Planning - Case Comments

Project Number: PR-2024-011242

Application Number: SI-2025-00079

Project Name: 1401 Innovation Parkway SE- PNM (ESS)

PUBLIC SERVICE COMPANY OF NEW MEXICO
SANDIA BESS SITE
PROJECT SITE PLAN
CONSTRUCTION DOCUMENTS
APN 1-021-055-162-512-2-06-67
CITY OF ALBUQUERQUE
NEW MEXICO

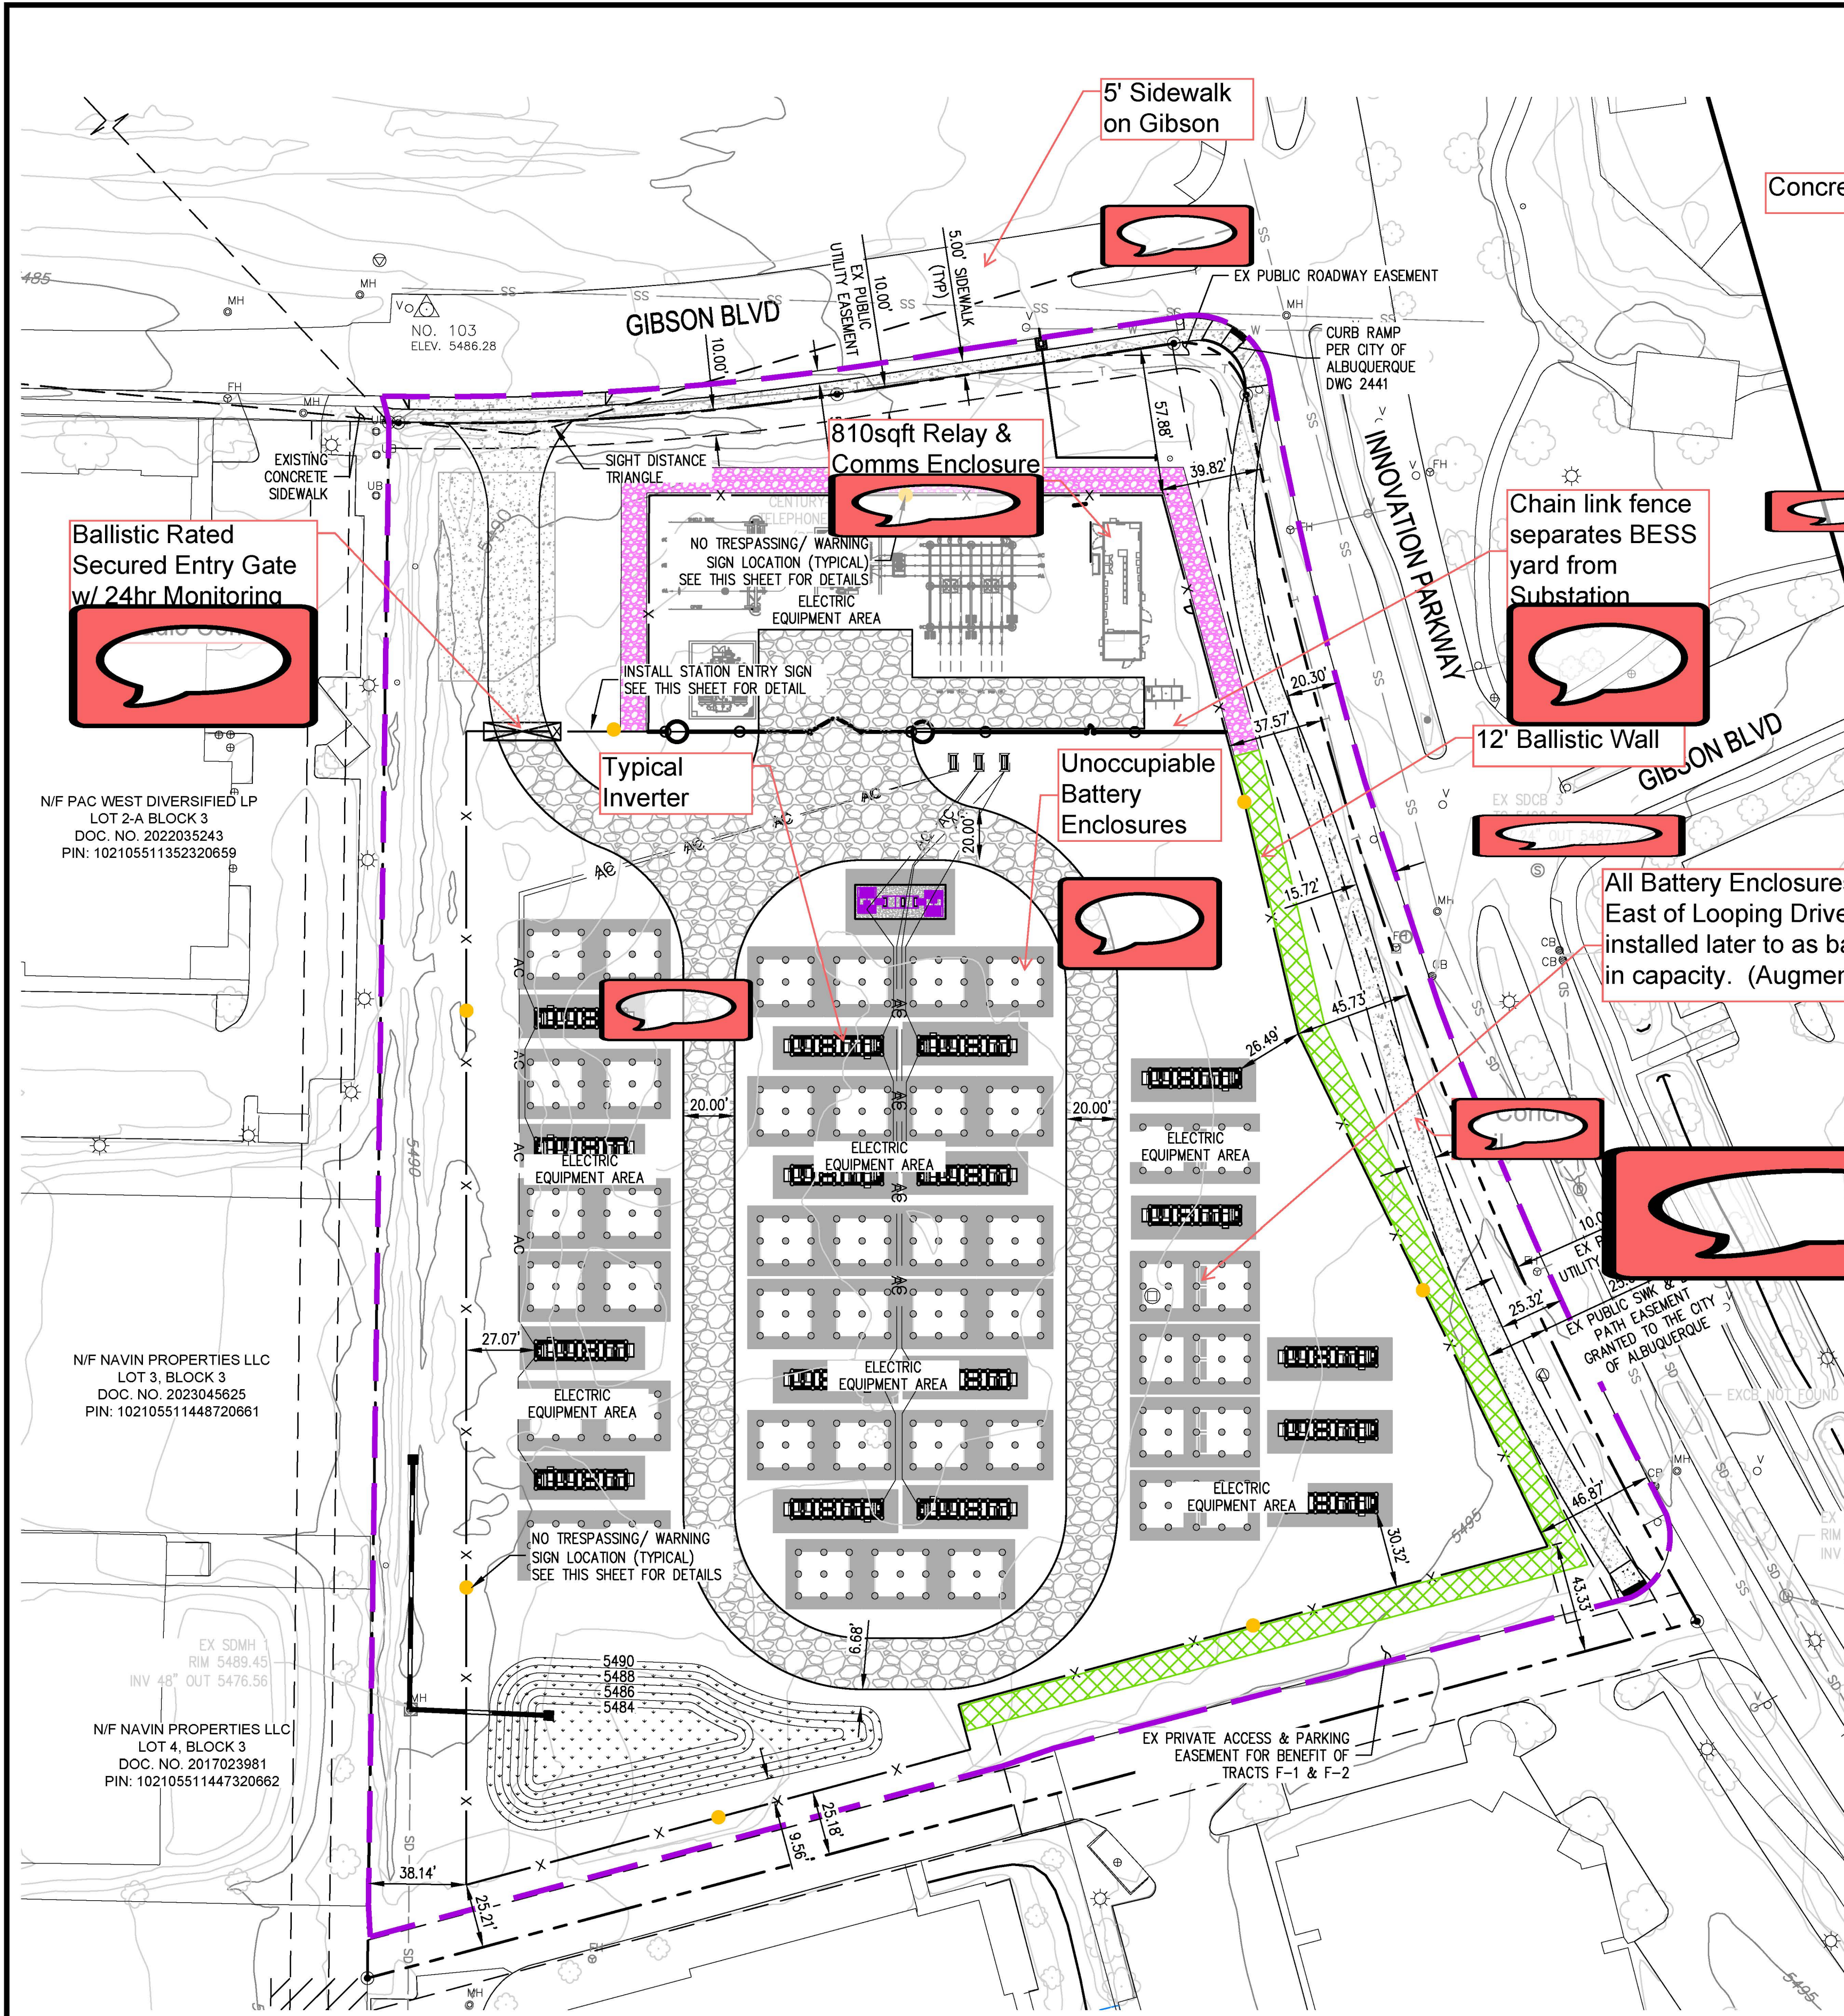
A permit will need to be obtained for the sign. Verify compliance with Sandia Science and Technology Park sign requirements per 6-5(G)(3)(c). Located on page 48 of the SSTP Master Plan. Link provided below:

PNM RESPONSE: PNM is aware of the necessary sign permit and will specifically reach out to SSA for approval on the sign. PNM does not wish to advertise the site, our overall goal it to have the site disappear behind the foliage and wall. Therefore and we do not intend on placing a large sign at the intersection of Gibson and Innovation defined the SSA master plan. There will be a smaller sign, mounted on the wall adjacent to the entrance gate only. This sign, as well as a the warning signs, are pictured on page 1 of the updated site plan.
